KIRKLEES METROPOLITAN COUNCIL INVESTMENT & REGENERATION SERVICE

DELEGATED DECISION TO DETERMINE PLANNING APPLICATIONS

Reference No:	2023/62/93232/W
Site Address:	12, Fartown Green Road, Fartown, Huddersfield, HD2 1AA
Description:	Alterations to convert dwelling into 6 bedroom House of Multiple Occupation
Recommending Officer:	Tom Hunt

Officer Report

Drawing
UD-493

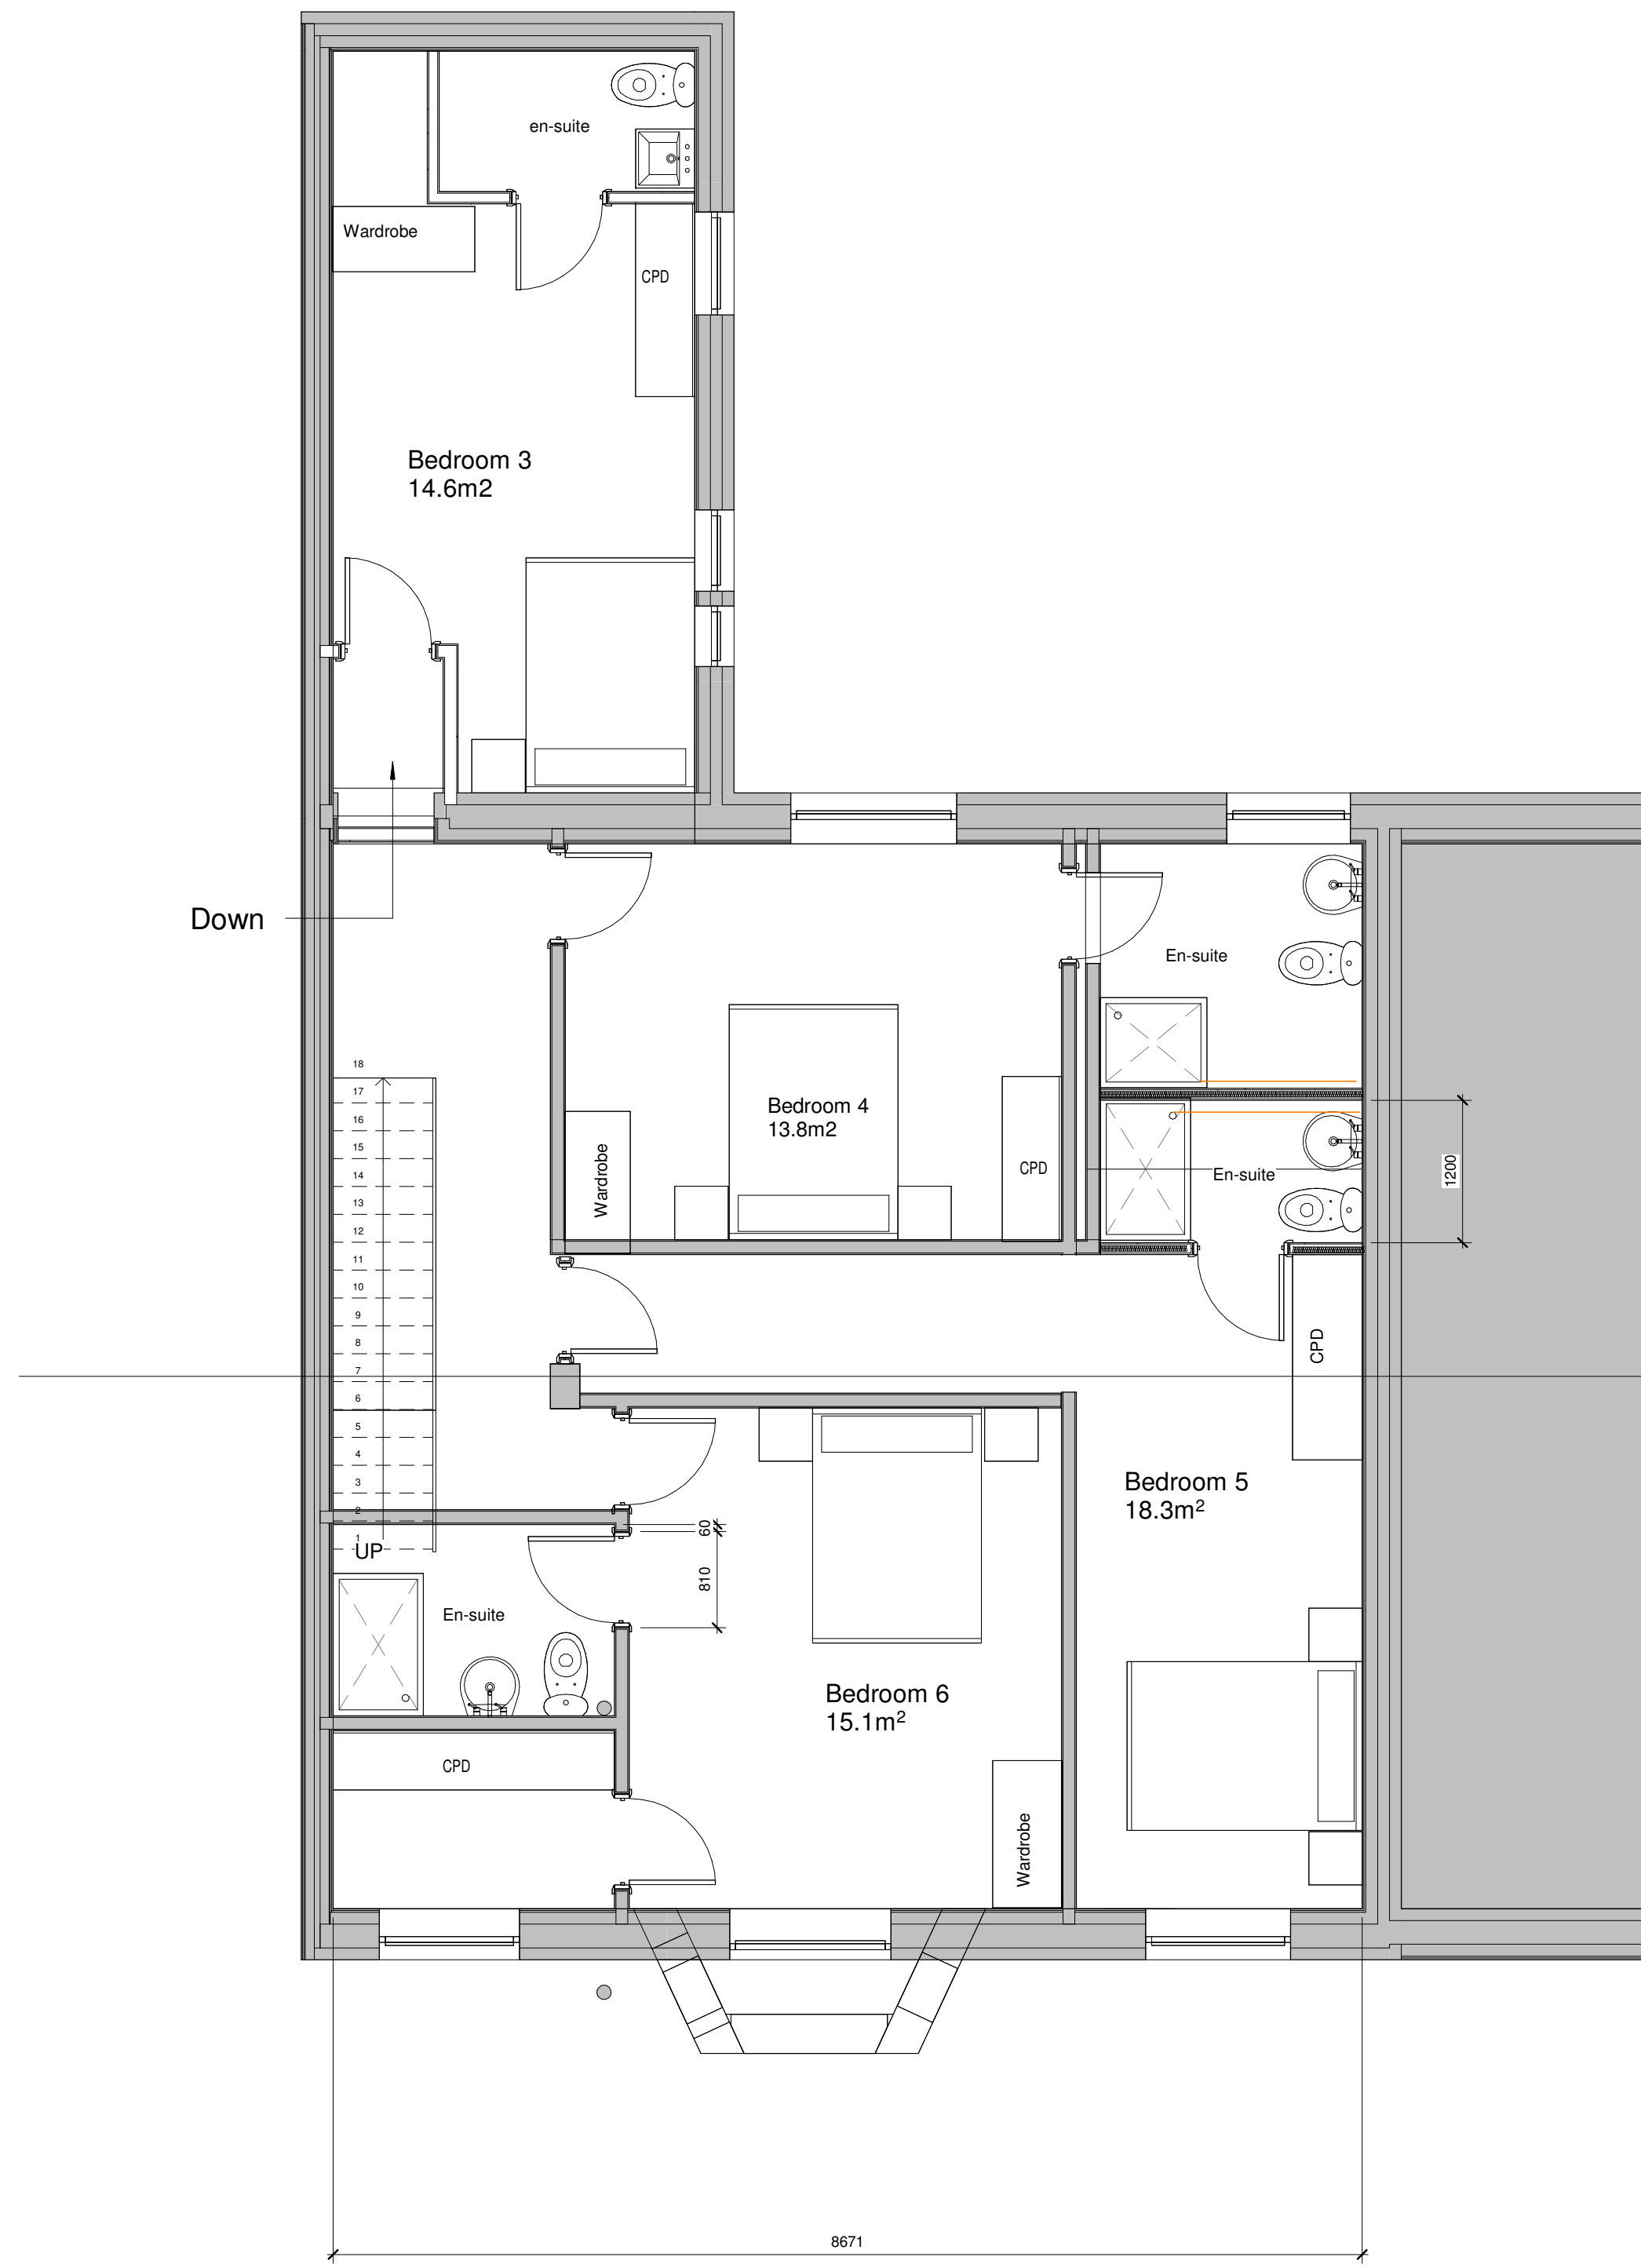
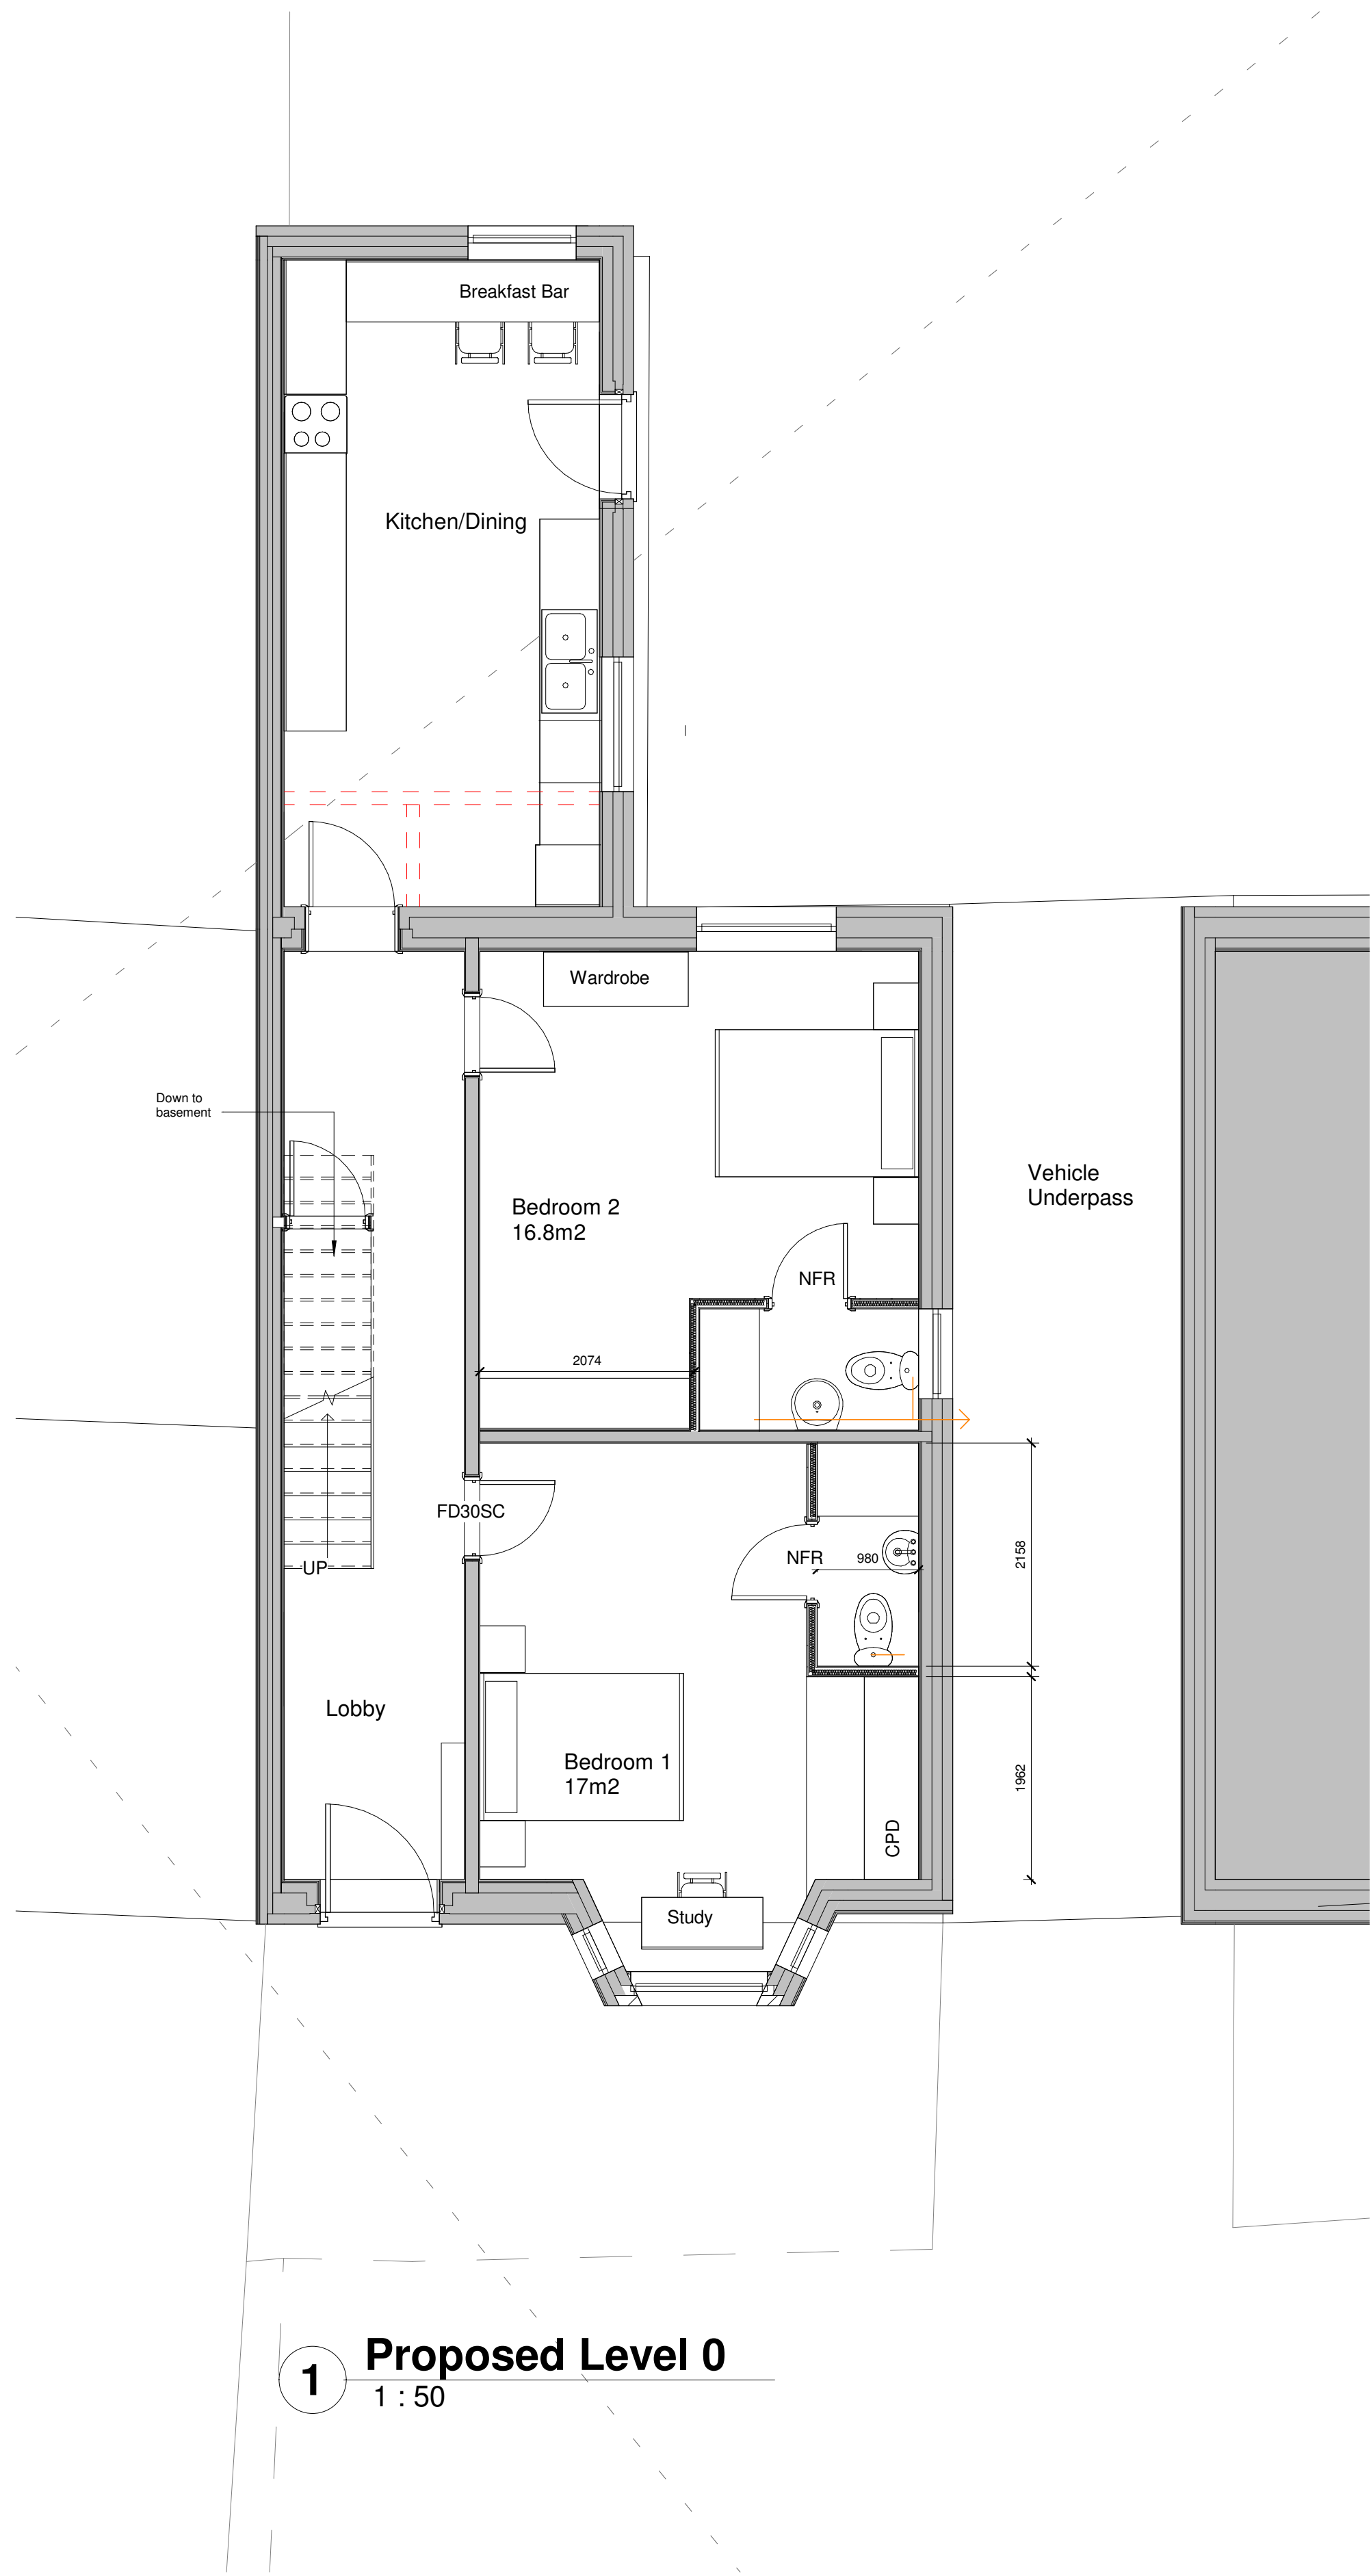
The case officer considered the application on review and sought additional information on parking layout with a swept path analysis (to avoid encroaching on neighbouring land) following discussion with the Highway Development Management Officer. A new amended plan was submitted with a reduced parking provision which achieves a feasible swept path analysis and sufficient bin capacity.

The Council seeks to ensure that new developments have an acceptable impact on highway safety and provide sufficient parking. The Highway Development Management team were informally consulted and initially raised concerns over the feasibility of the original proposed parking arrangements. Following provision of plans with sufficient turning potential demonstrated by a swept path analysis, which avoids vehicles encroaching onto neighbouring land, Officers concur that this would now be acceptable.

Standard communal provision is calculated at the rate of 180 litres per apartment/HMO bedroom for each type of waste. Applying the above calculation for the current application would require 1,080 litres for general waste and the same for mixed recyclables. The layout shows six 240ltr bins per waste stream have been set out to the rear which would marginally exceed the recommended capacity for a six double bedroom HMO. Whilst the bin presentation point to the rear may be moderately further than desired, the siting of the bins to the rear would visually avoid bin clutter and fire risk by siting the bins too close to the property. It is also noted that whilst a 1100 Eurobin per waste stream could have been provided, this would not be as manoeuvrable as a standard capacity bin so Officers accept that the siting would achieve the most realistic solution.

proposed provision of five off street parking spaces in light of its sustainable location.
